Fosse Green Energy

EN010154

28 April 2026

8.14 Statement of Common Ground with Prax / BPA

**TYPICAL TRENCHLESS CROSSING PLAN VIEW**

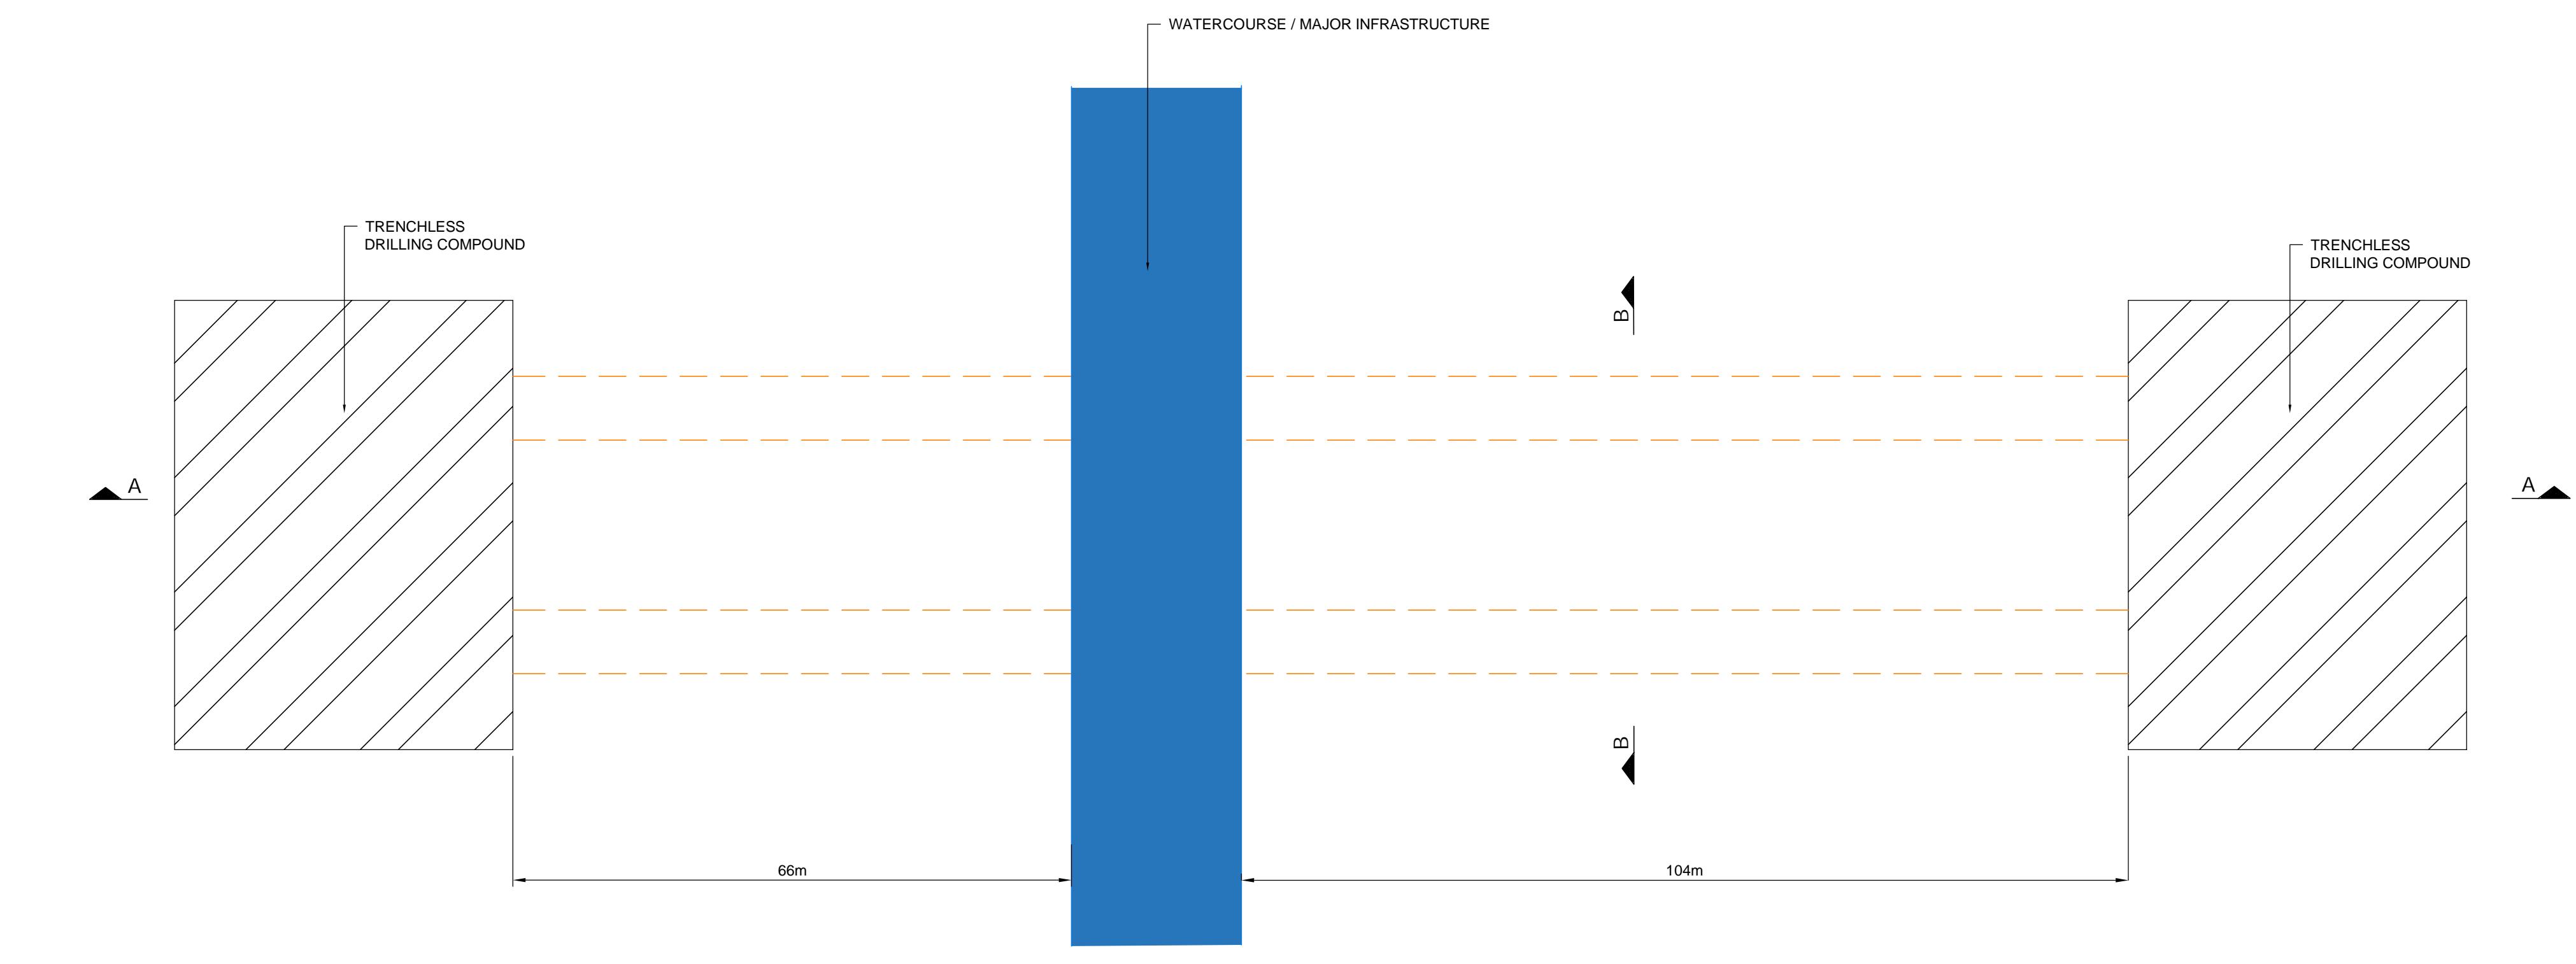
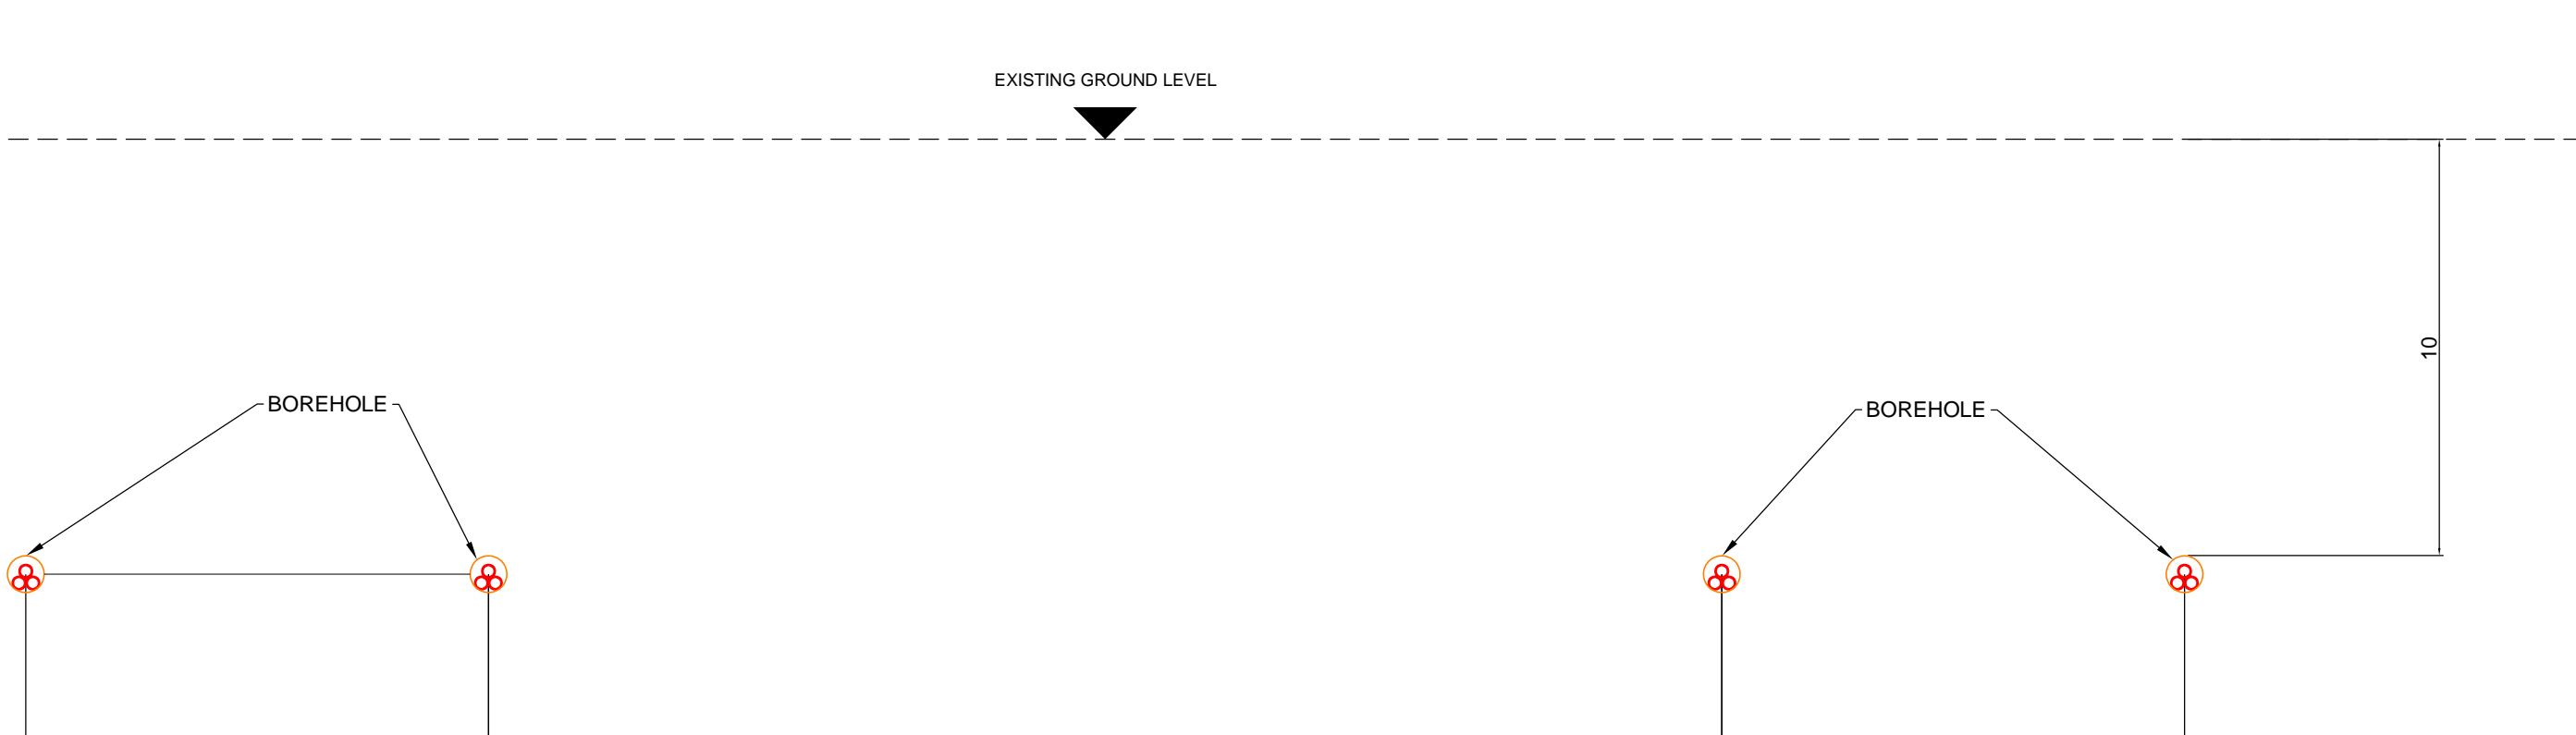
Reference	Description of Matter	Prax Position	Applicant Position	Status
4.2.1	Pipeline crossing	<p>The Proposed Development will involve the crossing of the Prax Pipeline with a high voltage electricity cable ("the Cable"). The Cable will be laid underground in close proximity to the Prax Pipeline. Prax has fundamental concerns relating to (inter alia) risk and safety assessments relating to the proposed interaction with the Prax Pipeline, the ability for the Proposed Development to be carried out safely within the Order limits, the ability of the Order to deliver the necessary rights for any necessary mitigation, and the lack of agreement in respect of appropriate protective provisions and indemnities. The following information is therefore required:</p> <ul style="list-style-type: none"> a) full details what works and working methods are proposed within 20 meters of the Prax Pipeline; and b) how close the Project Works will be to the Prax Pipeline and 	<p>The Applicant's position with regard to the AC Interference Modelling Study (or Risk Assessment) is identified at matter 3.1.2.</p> <p>The Applicant is in the process of negotiating bespoke protective provisions with FF and provided comments on FF's draft protective provisions on 22 April 2026 and following receipt of comments from FF on 24 April, provided further comments on on 27 April 2026.</p> <p>Further information on the proposed works, offset distances, and crossing angle are provided in the updated AC interference modelling report and engagement is continuing with Prax to secure appropriate protective provisions which reflect this.</p>	Under discussion

Reference	Description of Matter	Prax Position	Applicant Position	Status
		<p>modelling data to show the predicted levels of AC (Alternate Current) interference ("AC interference") likely to be caused thereby and whether these are within British Standard safety limits; and</p> <p>c) whether a final decision has been made as to the crossing angle currently proposed in respect of the Prax Pipeline (as this will have a direct impact on AC interference). Initial discussions have indicated that the Applicant wishes to cross the Prax Pipeline at a 60 degree crossing angle. An angle less than 90 degrees of crossing will make the need for mitigation more likely; and</p> <p>d) what mitigation works (if any) are envisaged to:</p> <ul style="list-style-type: none"> (i) safeguard the Prax Pipeline from physical harm during the works, and (ii) to protect the Prax Pipeline in the future (once the Cable is

Reference	Description of Matter	Prax Position	Applicant Position	Status
		<p>energized) from potential damage from AC interference, as this could seriously damage the measures currently in place to protect the Prax Pipeline from corrosion; and</p> <p>e) to the extent that mitigation measures are necessary (due to operational or safety concerns) that the draft Order has included the necessary land and rights within the draft Order limits. Typically mitigation works might require:</p> <ul style="list-style-type: none"> (i) the installation of multiple subsurface 'sacrificial' zinc strips either side of and parallel to the Prax Pipeline together with surface mounted monitoring equipment and surface to subsurface cabling); and/or (ii) the installation of a concrete or other barrier

Reference	Description of Matter	Prax Position	Applicant Position	Status
		<p>above or below the Prax Pipeline; and/or (iii) a concrete 'raft' above the Prax Pipeline to protect against vehicles / other loads).</p> <p>Prax's position is further outlined at 3.1.1 and in AS-129. While the initial work undertaken to date is sufficient to confirm that there is a credible threat to the pipeline infrastructure, it is not yet possible to of quantify the effectiveness or sufficiency of any potential mitigation measures</p>
